### **Rocky Top, PPR-19-13 (Revised)**

**Please accept the following comments from El Paso County Public Health (EPCPH) for the project referenced above:**

**Mike McCarthy, El Paso County Public Health**  
719.575.8602, [mikemccarthy@elpasoco.com](mailto:mikemccarthy@elpasoco.com)  
22April2020

EXTENDED DETENTION BASIN PLAN

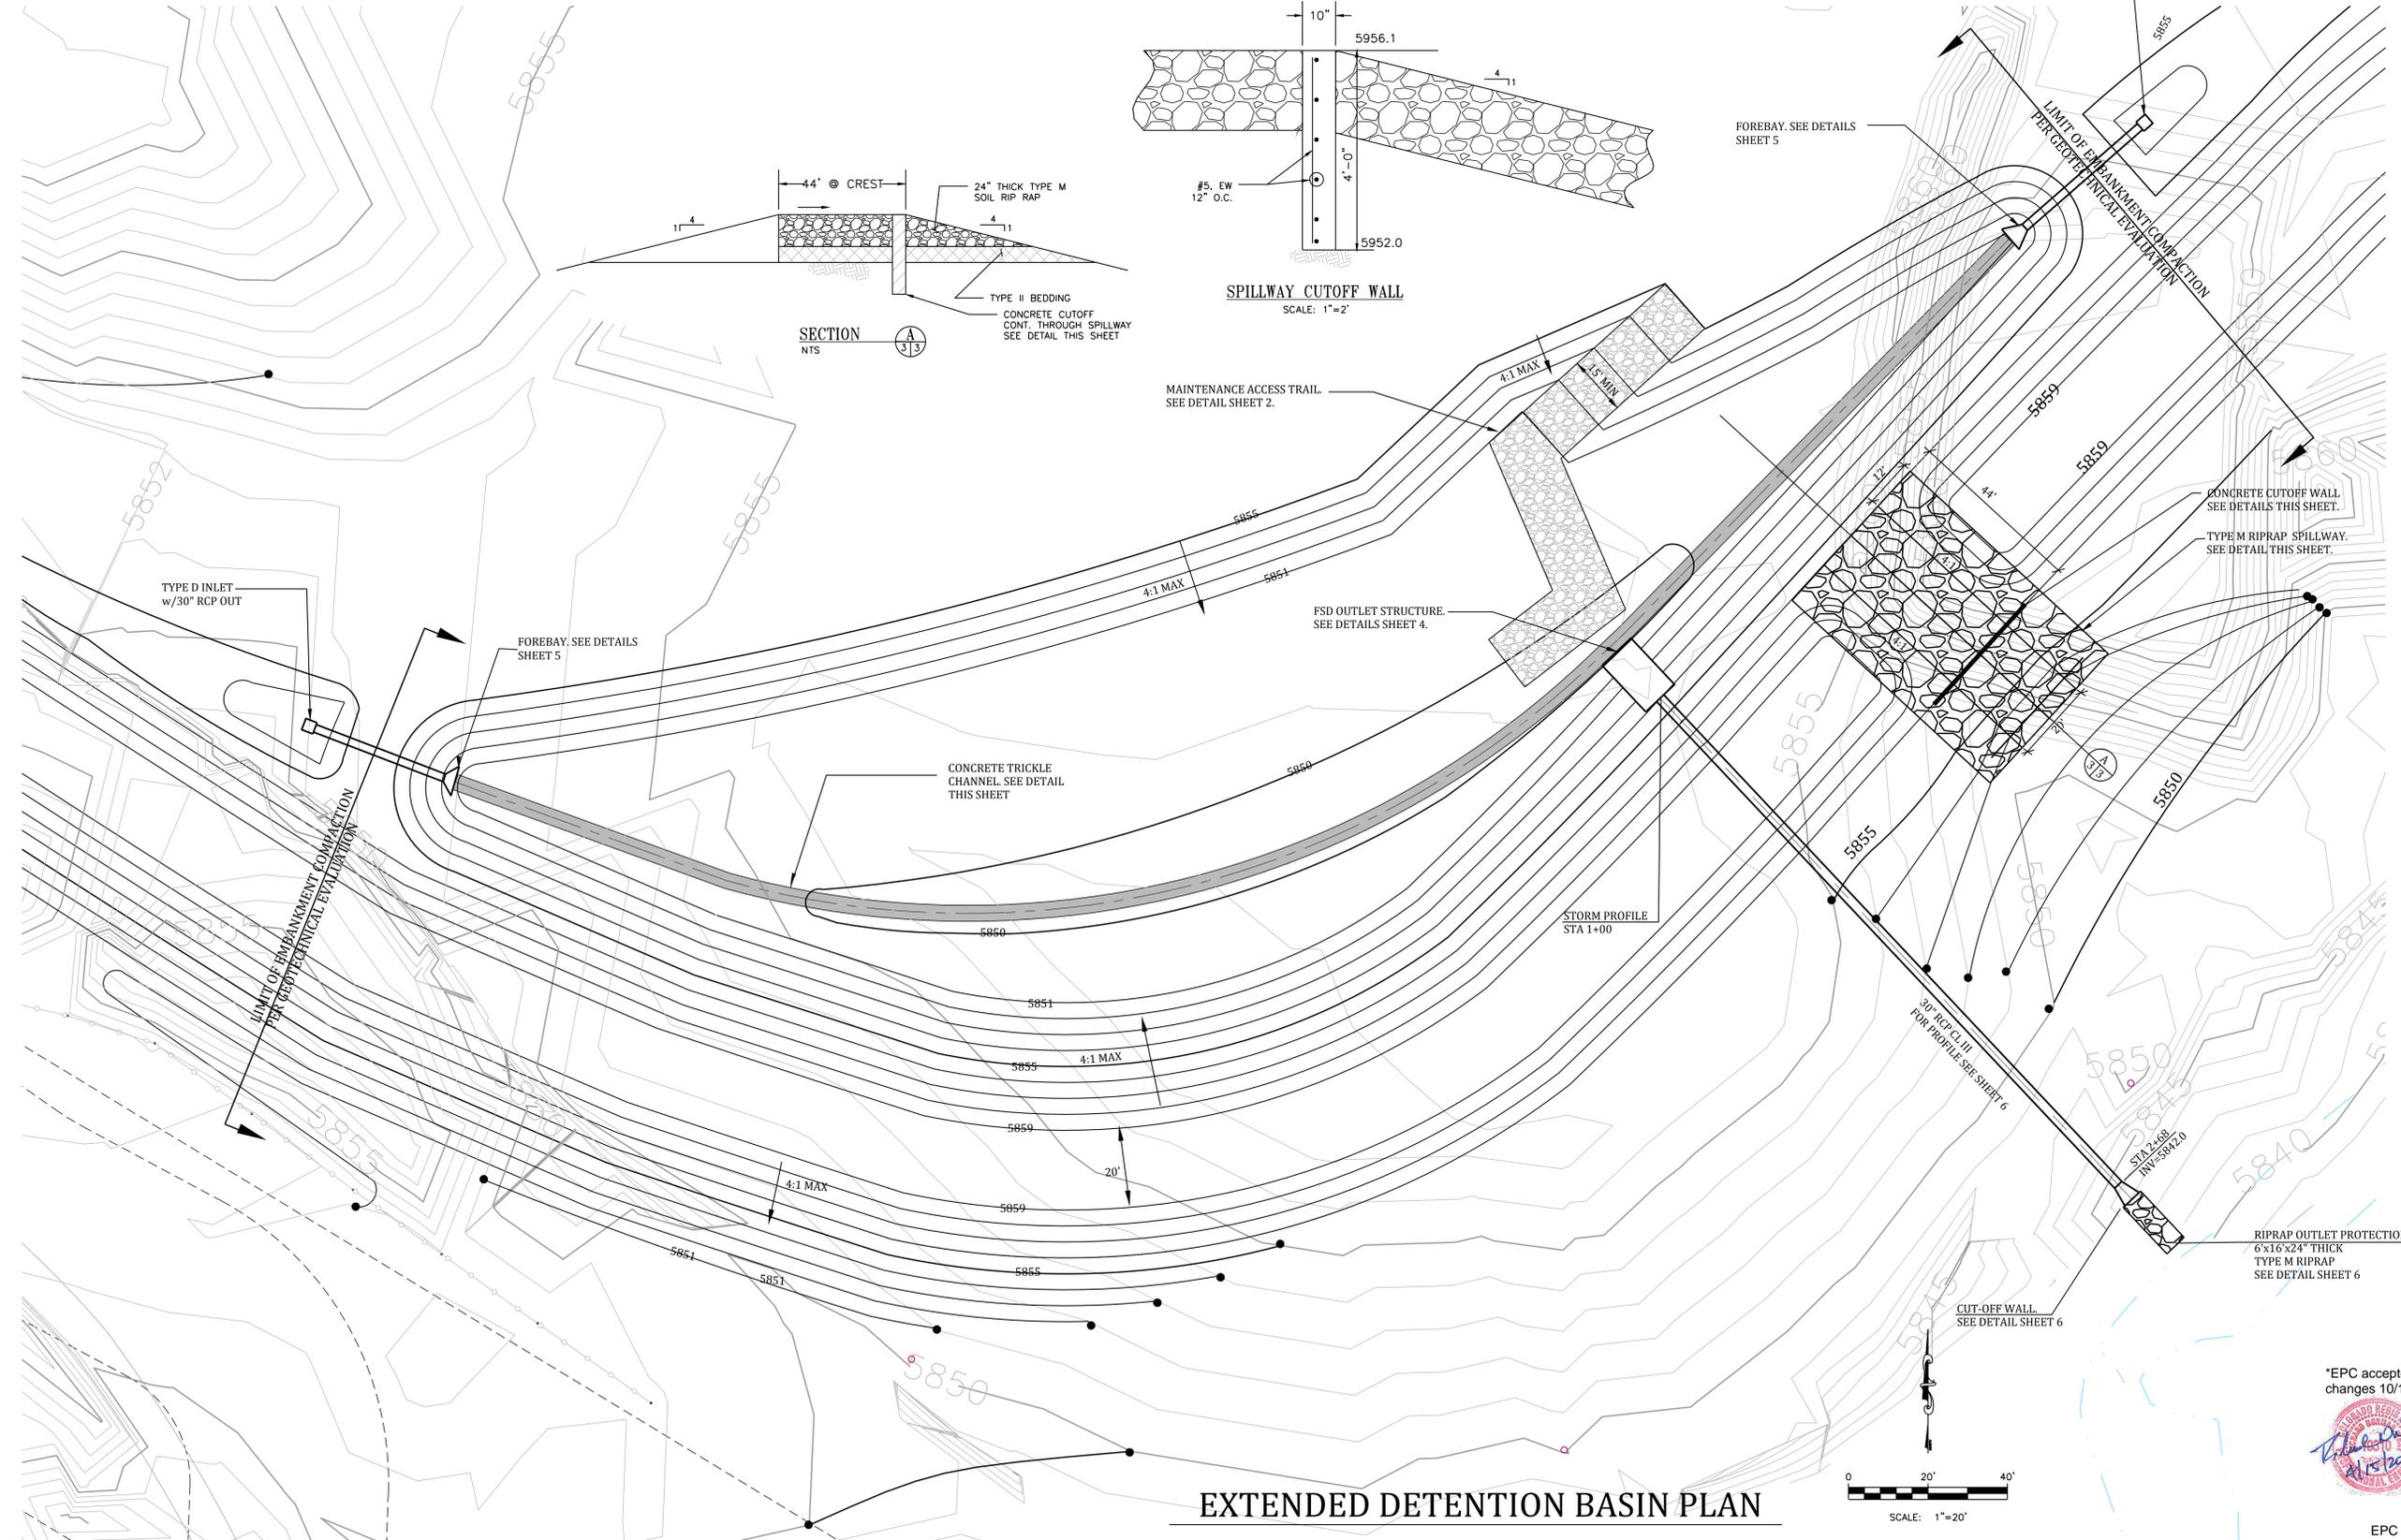
- The water quality basin must have mosquito control responsibilities included as a part of the construction design and/or the maintenance plan to help control mosquito breeding habitat and minimize the potential for West Nile Virus.
